Gatwick Airport Northern Runway Project

Statement of Common Ground Between Gatwick Airport Limited and Tandridge District Council – Tracked Version

VERSION: 2.0

DATE: JUNE 2024

Diagram 3.3.1: Model performance before and after adjustment, Generic zone

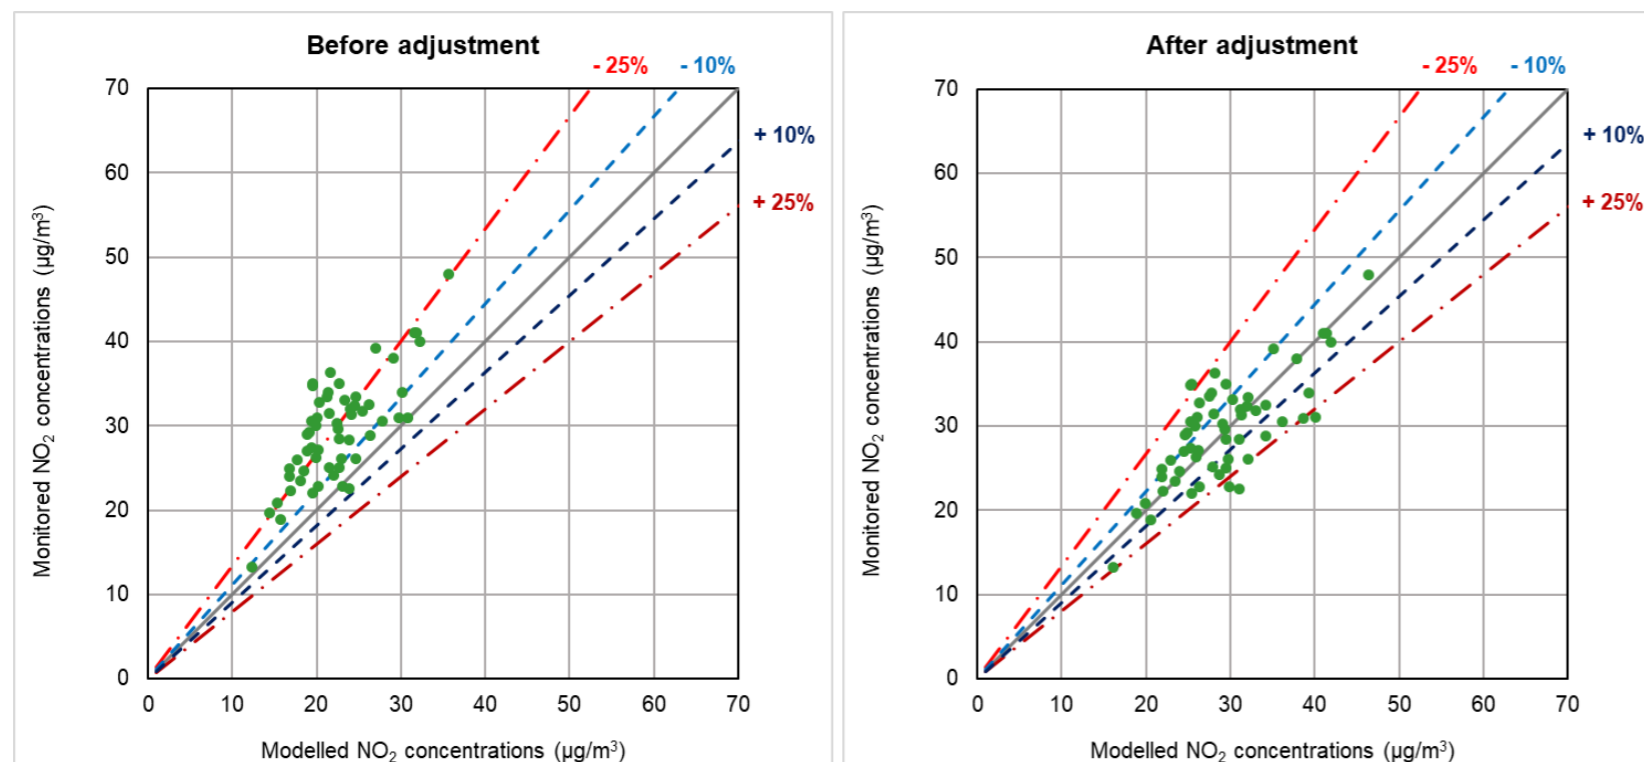
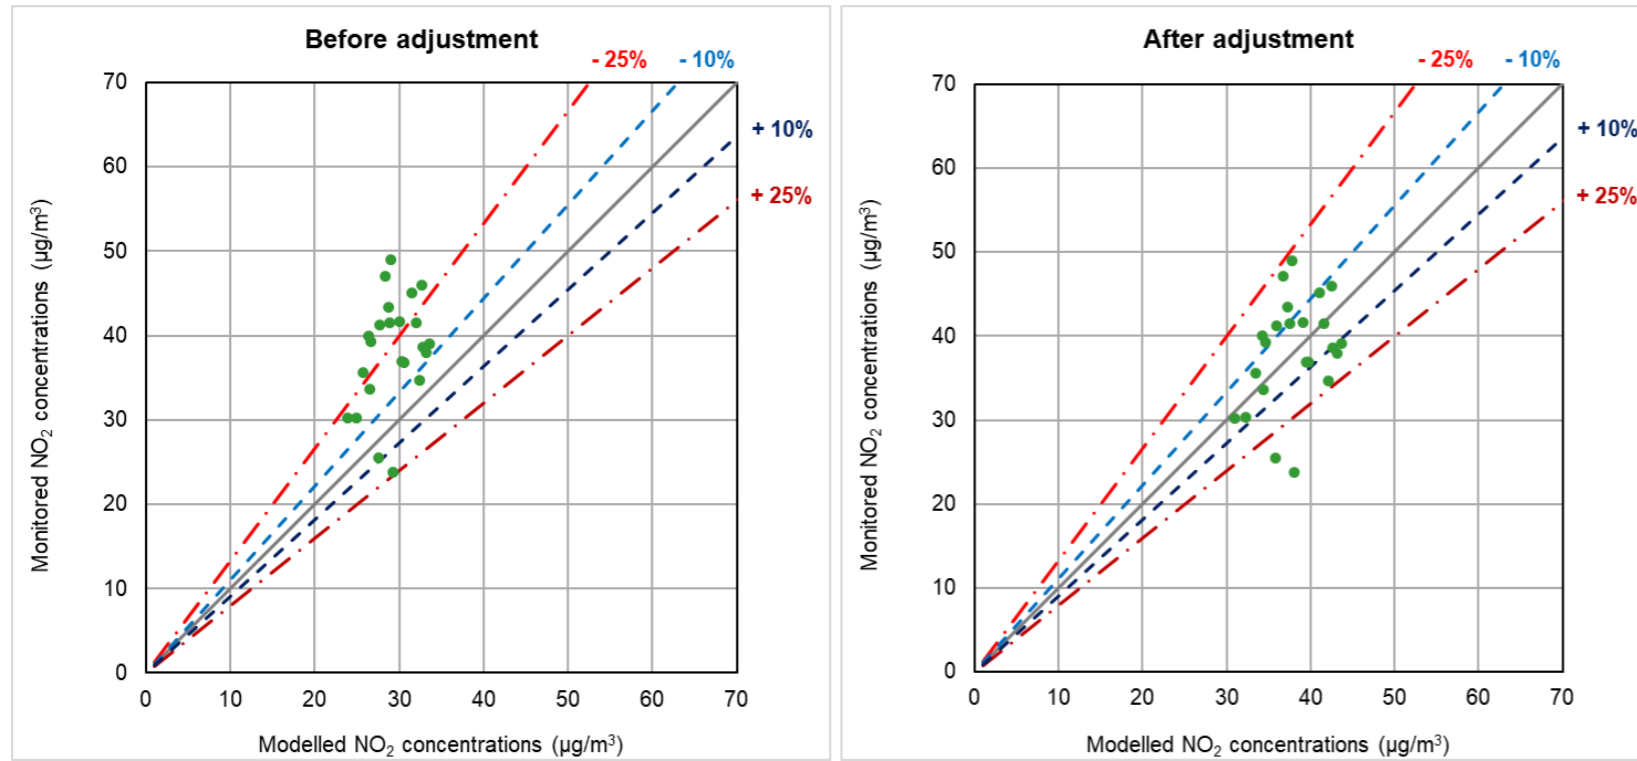
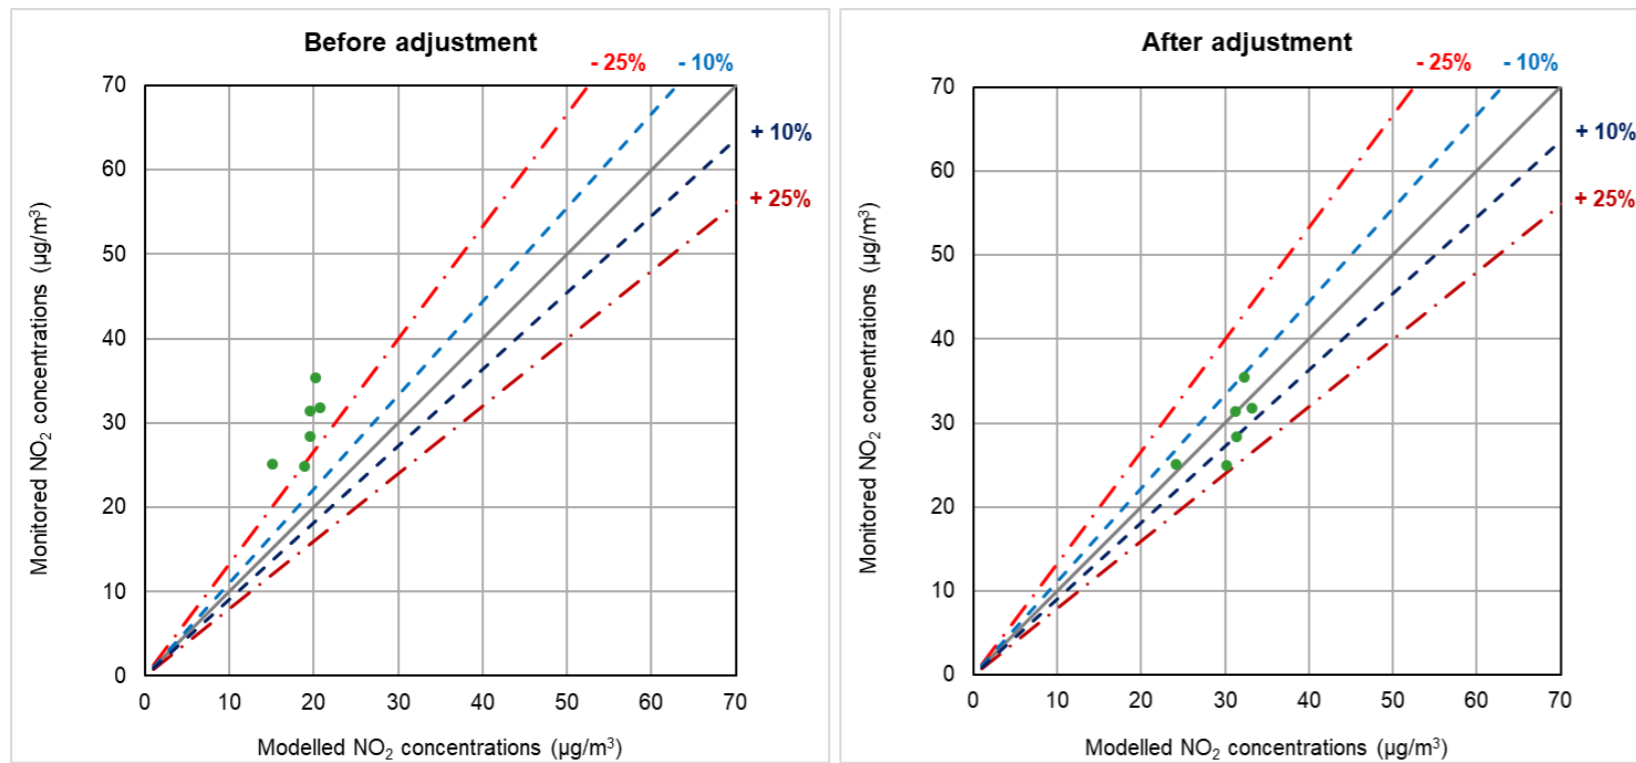
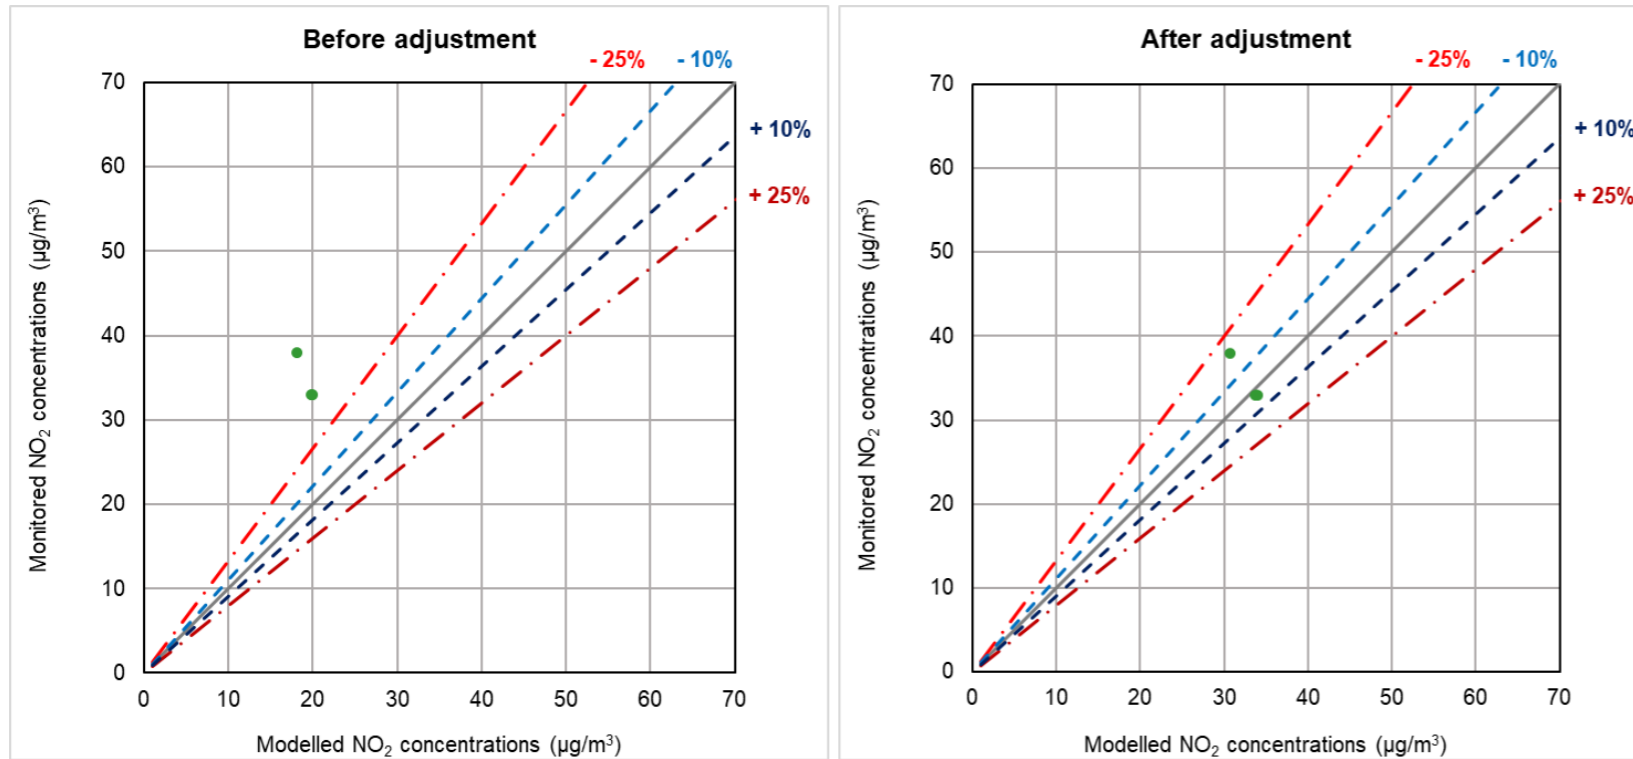
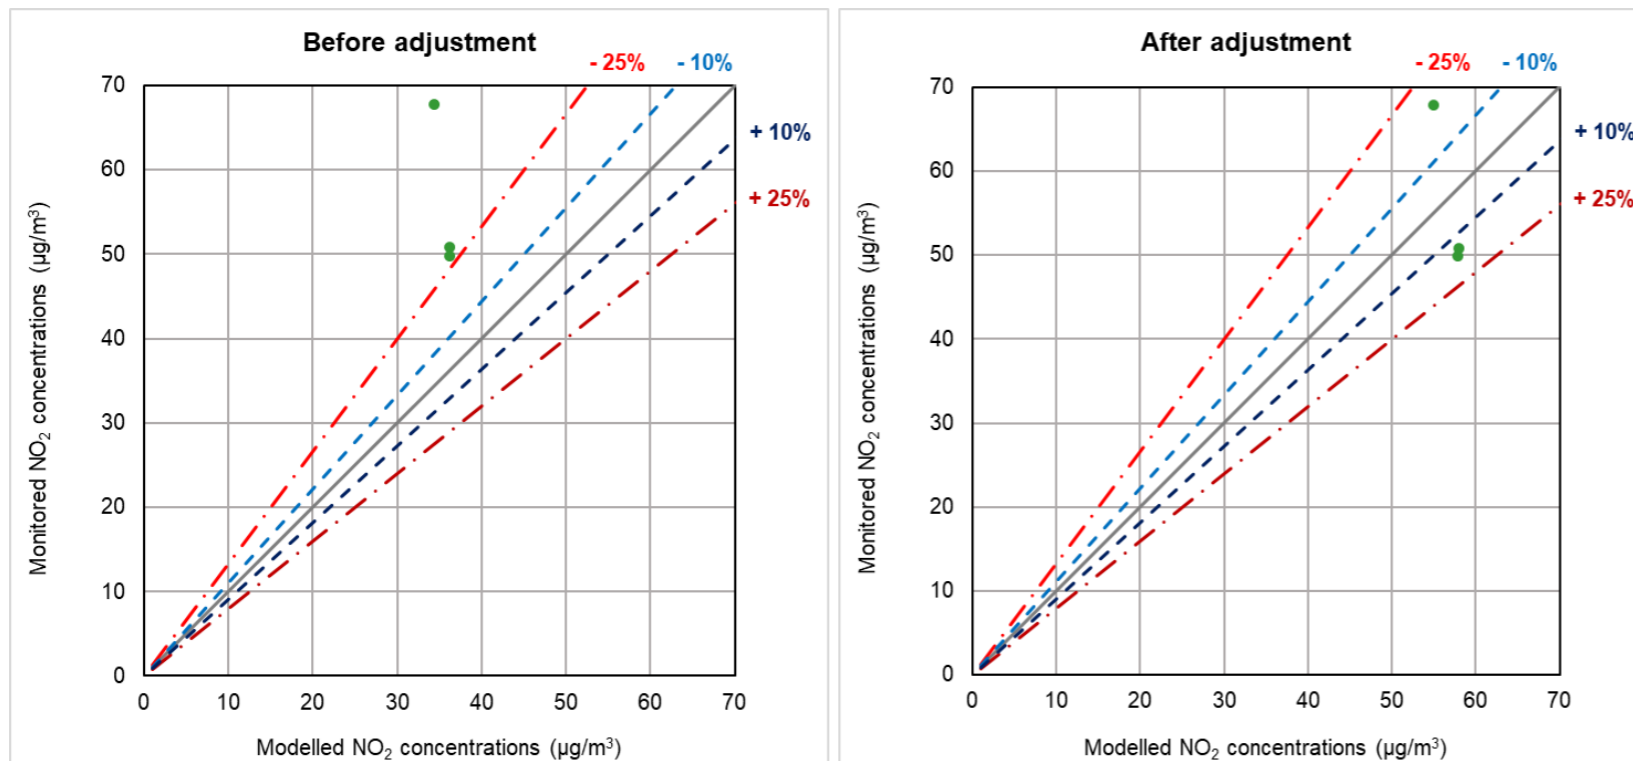
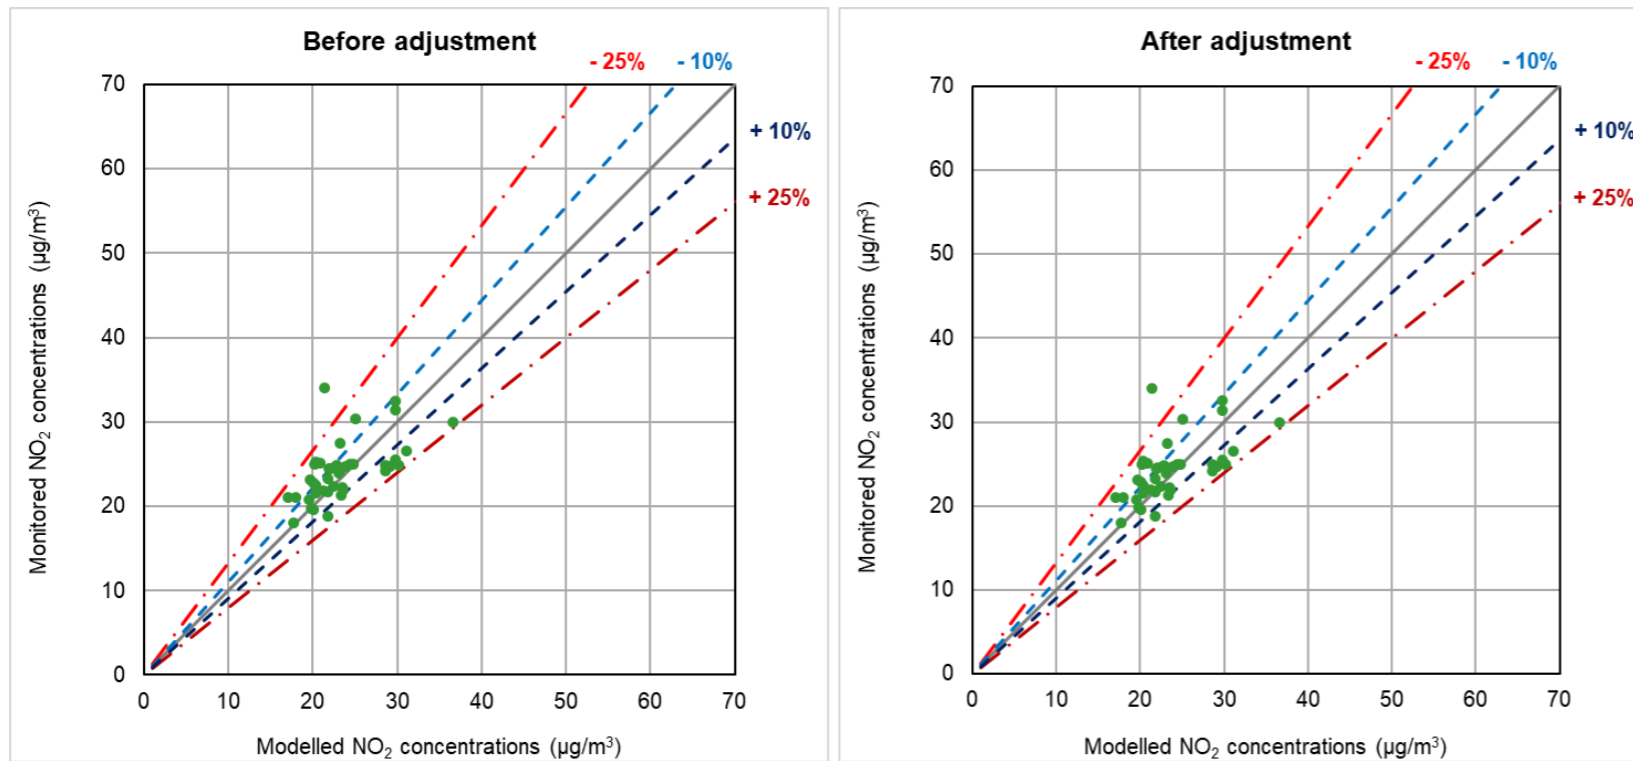
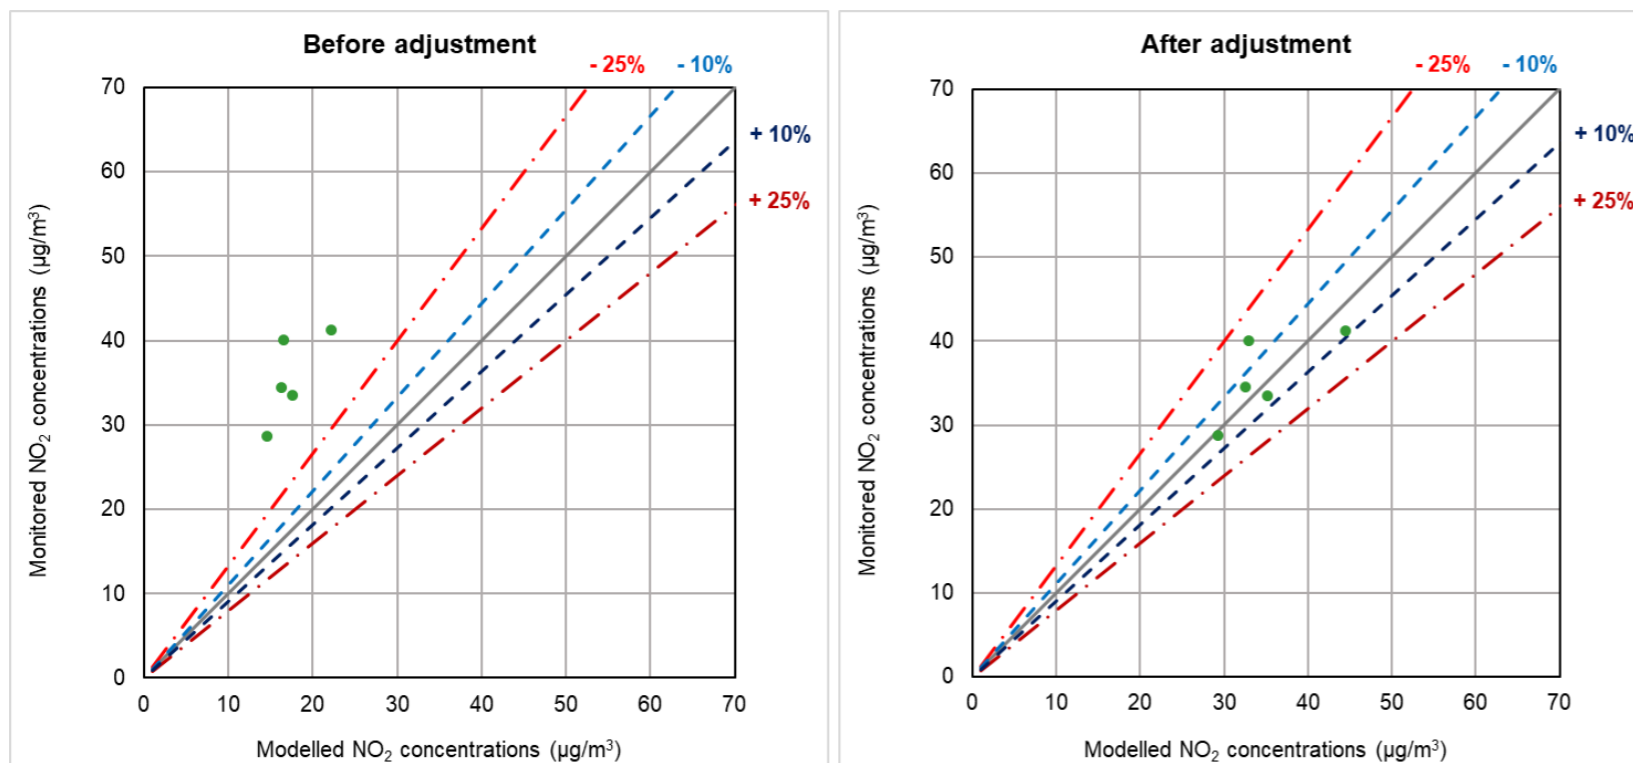
2.2.2.5	Verification zones	<p>TDC disagrees that enough justification was provided for the selection of different verification zones and why the model would be expected to perform differently in each area. A sensitivity test is required to</p>	<p>Full details of the model verification process are included in Section 3 within the ES Appendix 13.6.1. Table 3.3.1 provides details on the verification zones used.</p>	<p>ES Appendix 13.6.1 Air quality Data and Model Verification [APP-159],</p>	Under discussion

<p>demonstrate that the conclusions of the assessment would not change if a single verification factor were used.</p> <p>Updated position (Deadline 1): Further discussion is required on this point and the request for a sensitivity test examining the use of a single verification factor still remains.</p> <p>Updated position (Deadline 5): Gatwick Airport Limited (GAL) comments in paragraph 3.7.7 of their Response to Deadline 3 Submissions [REP4-031] that the air quality matters submitted by the Joint Local Authorities at Deadline 3 (Appendix A) [REP3-117] will be responded to by Deadline 5. This Appendix of air quality queries prepared by AECOM included a wide range of technical matters.</p>	<p>The verification methodology was agreed with local councils at the modelling methodology workshop in November 2022. Model files and results were provided to the TWG via email 18th August 2023.</p> <p>The process followed during the ES took into account feedback from the local authorities at the PEIR stage and following discussions on the agreed approach.</p> <p>Updated position (April 2024): The Applicant notes that the JLAs have provided a submission on air quality at Deadline 3. The Applicant will review this submission and respond accordingly.</p> <p>Updated position (Deadline 5): The Applicant has provided a response to the air quality matter submitted by the JLAs at Appendix A: Response to West Sussex Joint Local Authorities – Air Quality to The Applicant’s Response to Deadline 4 Submissions (Doc Ref. 10.38). The Applicant will respond at Deadline 6 to the JLAs’ review submitted at Deadline 4 [REP4-053].</p>	<p>Appendix A: Response to West Sussex Joint Local Authorities – Air Quality to The Applicant’s Response to Deadline 4 Submissions (Doc Ref. 10.38)</p>
